ONE EARTH SOLAR FARM
EN010159

WEST LINDSEY DISTRICT COUNCIL

RESPONSE TO ISH2 ACTION POINTS

Issue Specific Hearing 2 (ISH2): environmental matters

400kV EAST SUBSTATION LAYOUT ELEVATION

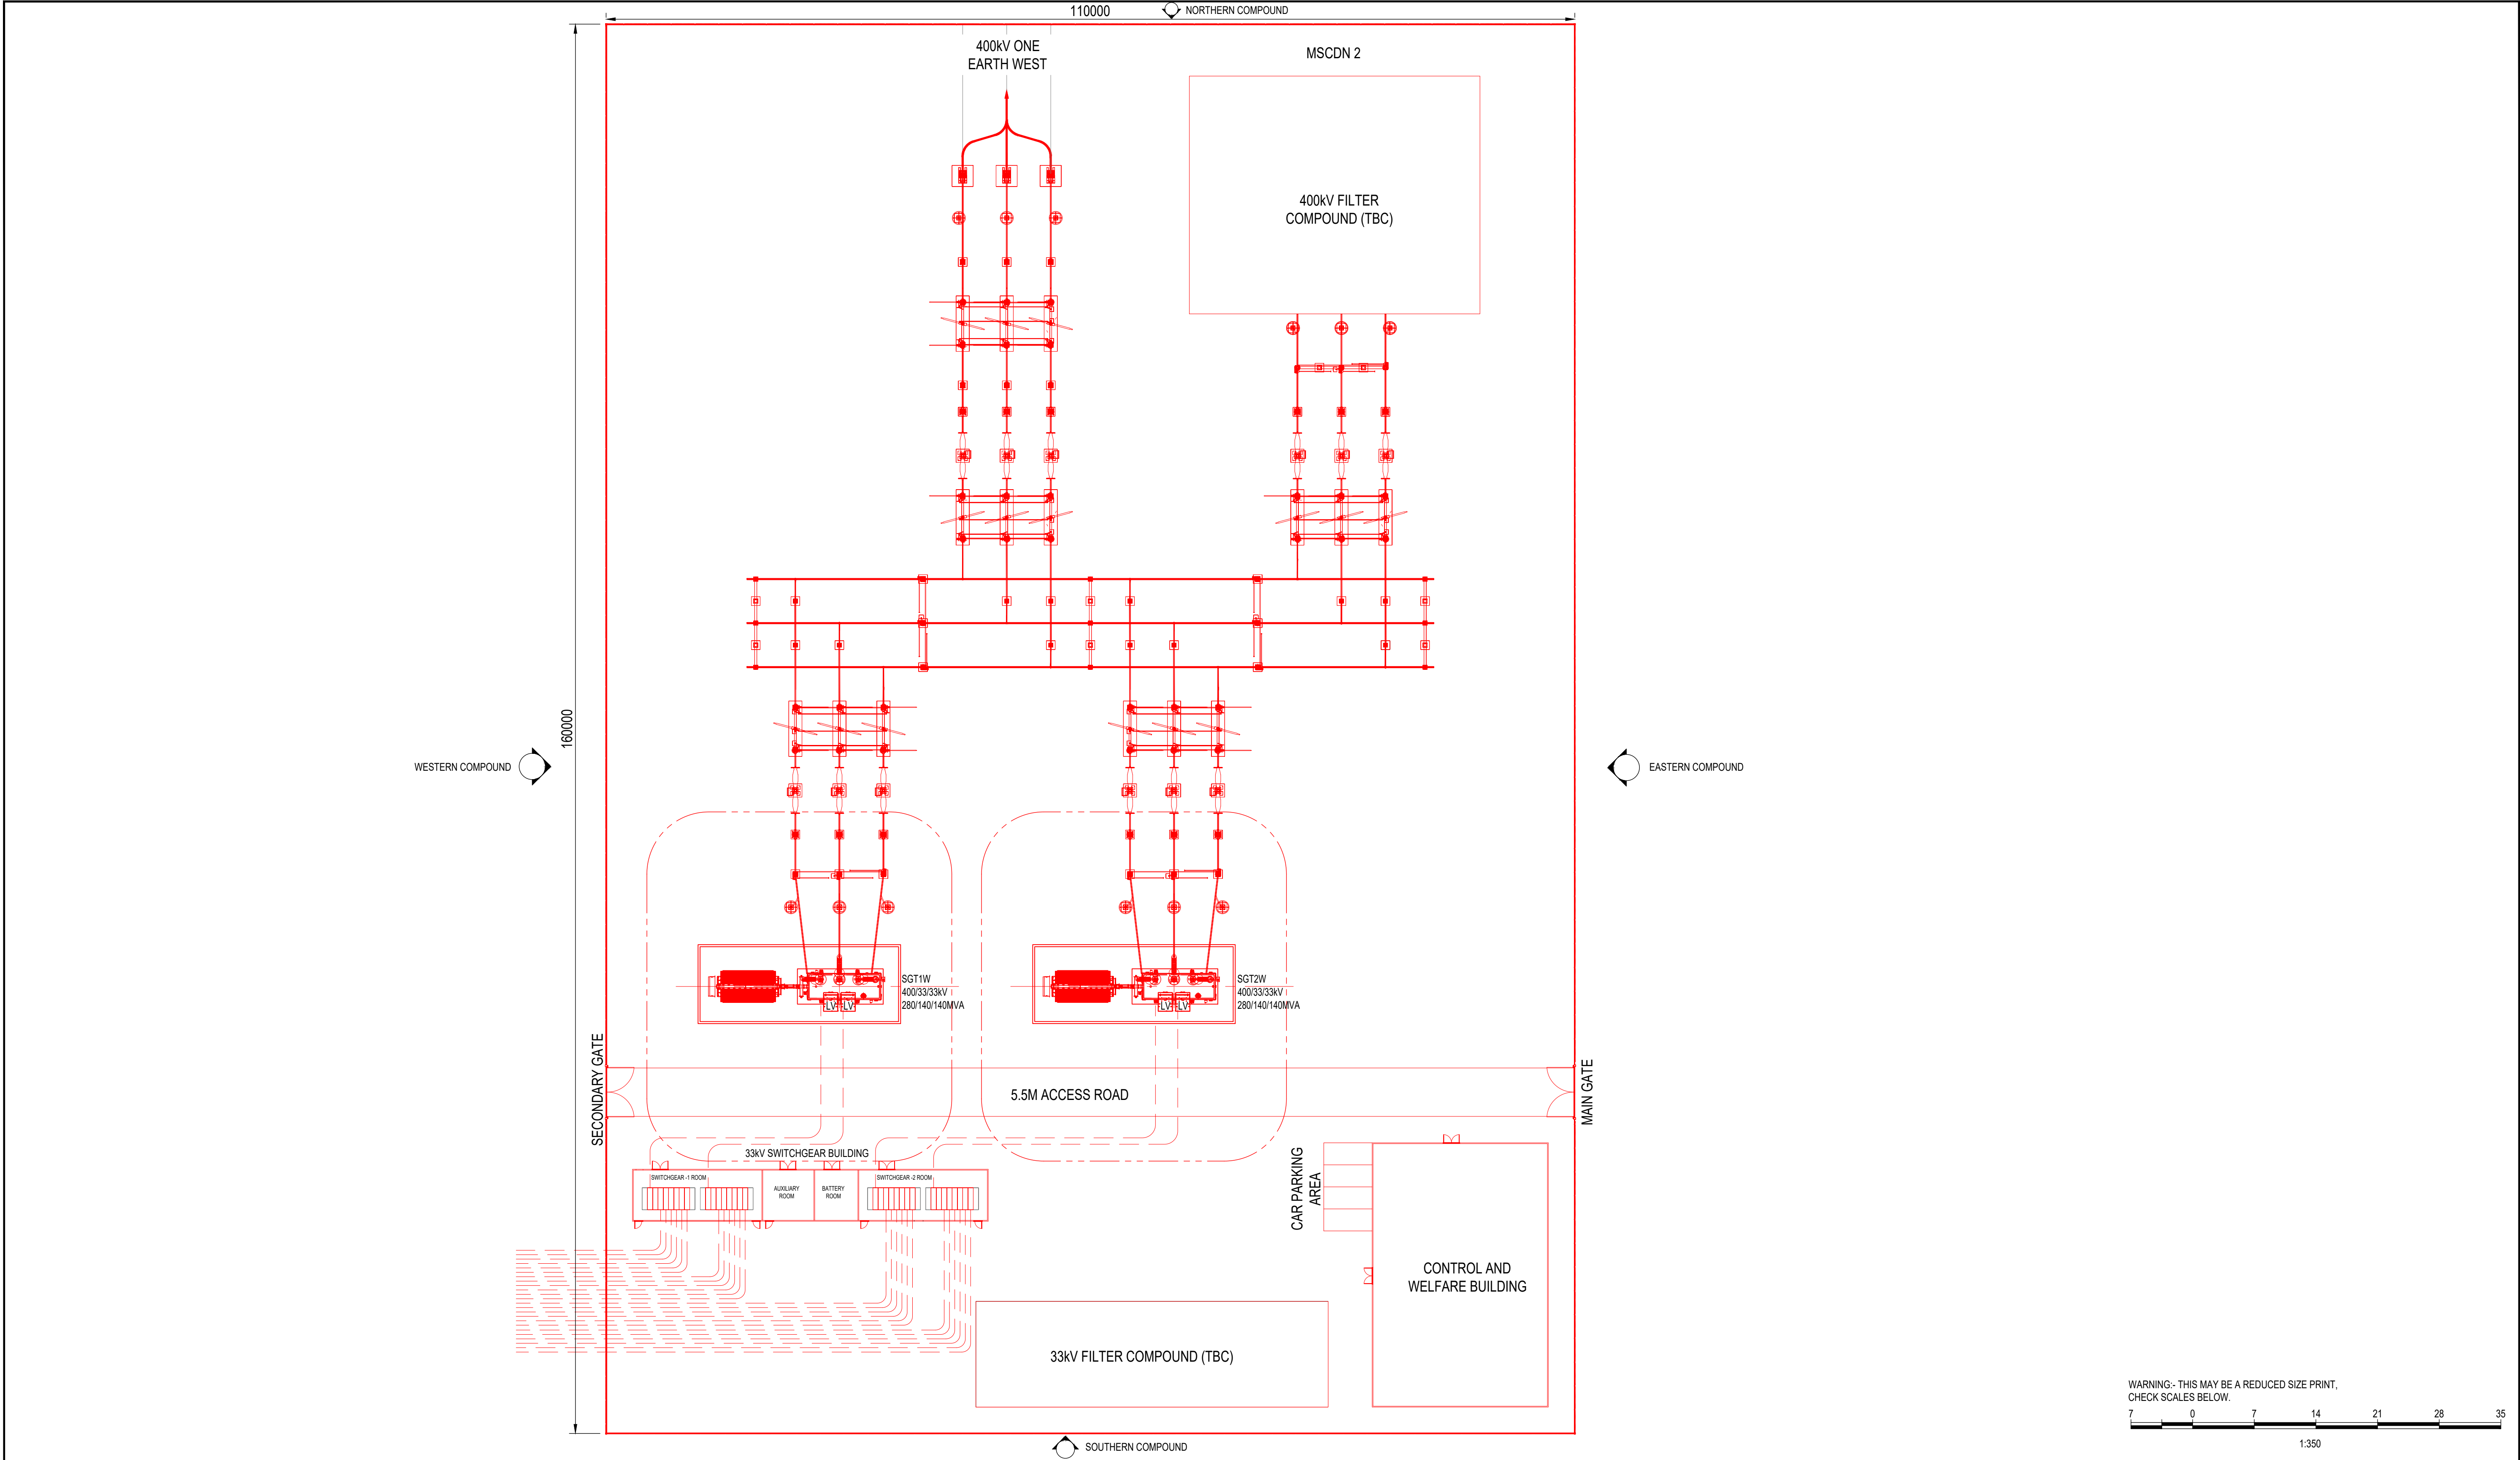
West Lindsey District Council has been working with the applicant's advisors to agree specific siting parameters for a suitable location for the eastern substation, should the DCO be approved. It is the view of WLDC, having reviewed cross section information, that the best location within the area identified by the applicant in the application documents as being for the BESS and substation is shown on the diagram below. WLDC would like to see a similar parameter for the eastern substation included on the certified plans accompanying the DCO.
